# CITY OF PORTLAND, MAINE

## PLANNING BOARD

October 29, 2015

Project Name:	Longfellow Apartments	Project ID:	2015-093
Address:	667 Congress Street	CBL:	046 C019 020
Applicant:	Redfern Properties, LLC		
Planner:	Shukria Wiar

BICYCLE RACK DETAIL
NOT TO SCALE

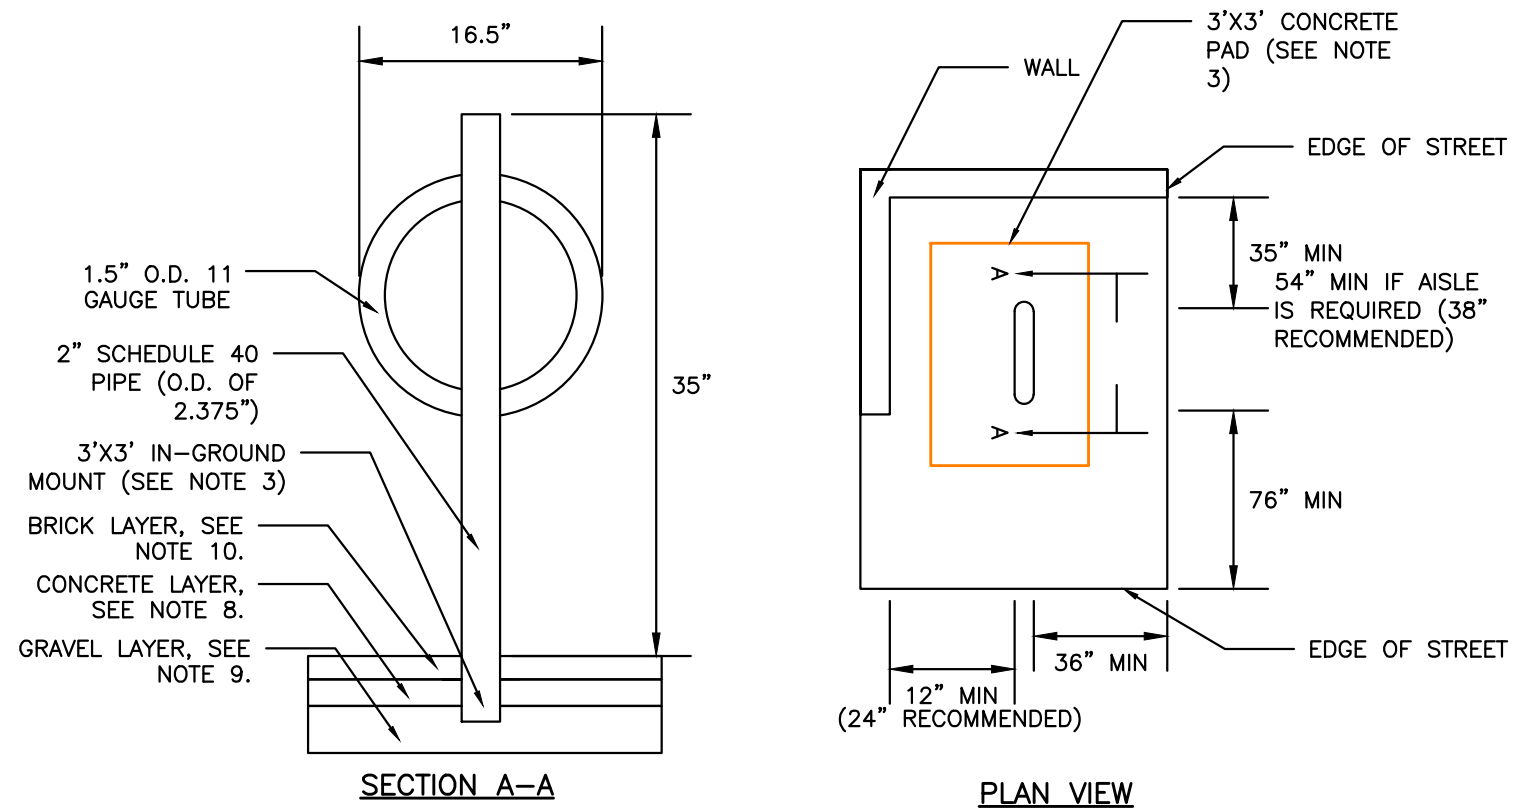
7. The bicycle hitch shall meet the Technical Standards in regard to mounting and color.

PREFERRED SIDEWALK RAMP LAYOUT AT CORNER INTERSECTION FOR SIDEWALK WITHOUT ESPLANADE
NOT TO SCALE

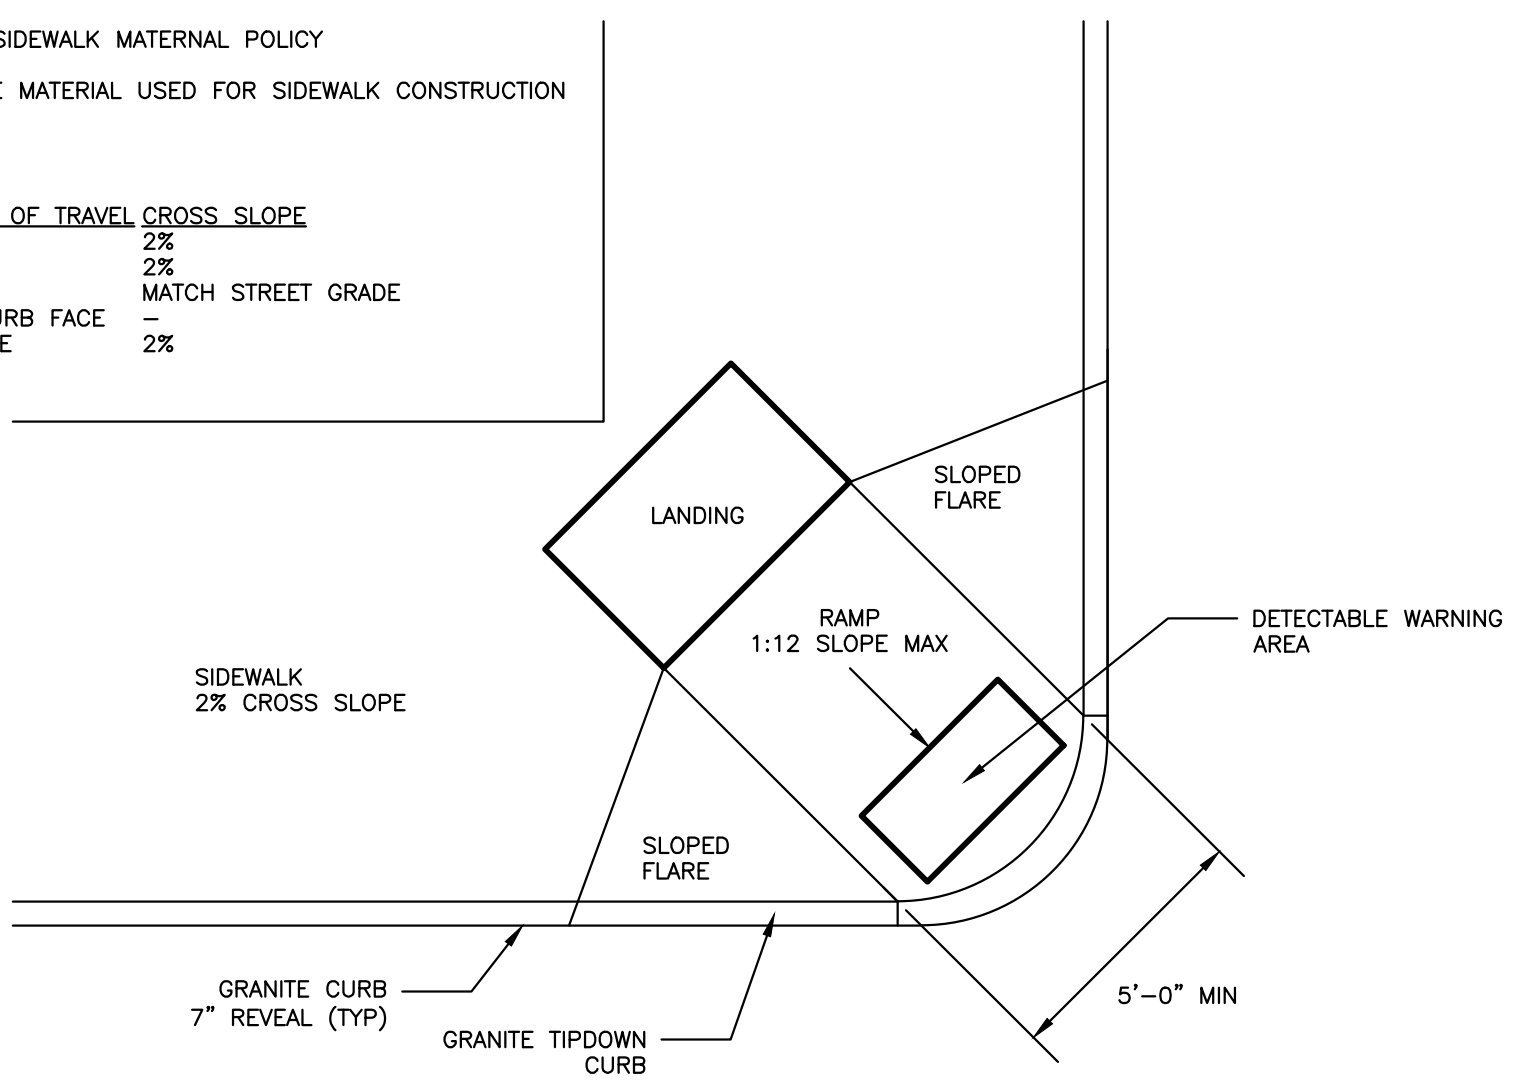
- c. Cross-slope and grade details will be required for the ADA ramps being proposed on Congress Street.
  - d. Eliminate the crosswalk on Avon Street.

5. The Consultant Stormwater Engineer comments, dated 10.21.2015, shall be addressed prior to the issuance of a building permit.
6. The ramps at the corner of Congress Street shall meet the Historic District detail Figure I-7A in the Technical Standards.

\* The alignment of the sidewalk ramps on Congress Street will need to direct pedestrians to the appropriate path of travel from an ADA perspective. Adjustments will need to be incorporated. Status: The ramp at corner of the Avon Street is unacceptable and alignment for walking parallel to Congress Street shall be provided. I would also note that the ramp at Vernon Place may need to change following the final configuration of the street. Final Status: I have reviewed the plans and generally find them to be acceptable. Specific cross-slope and grade details will be required as part of final construction.
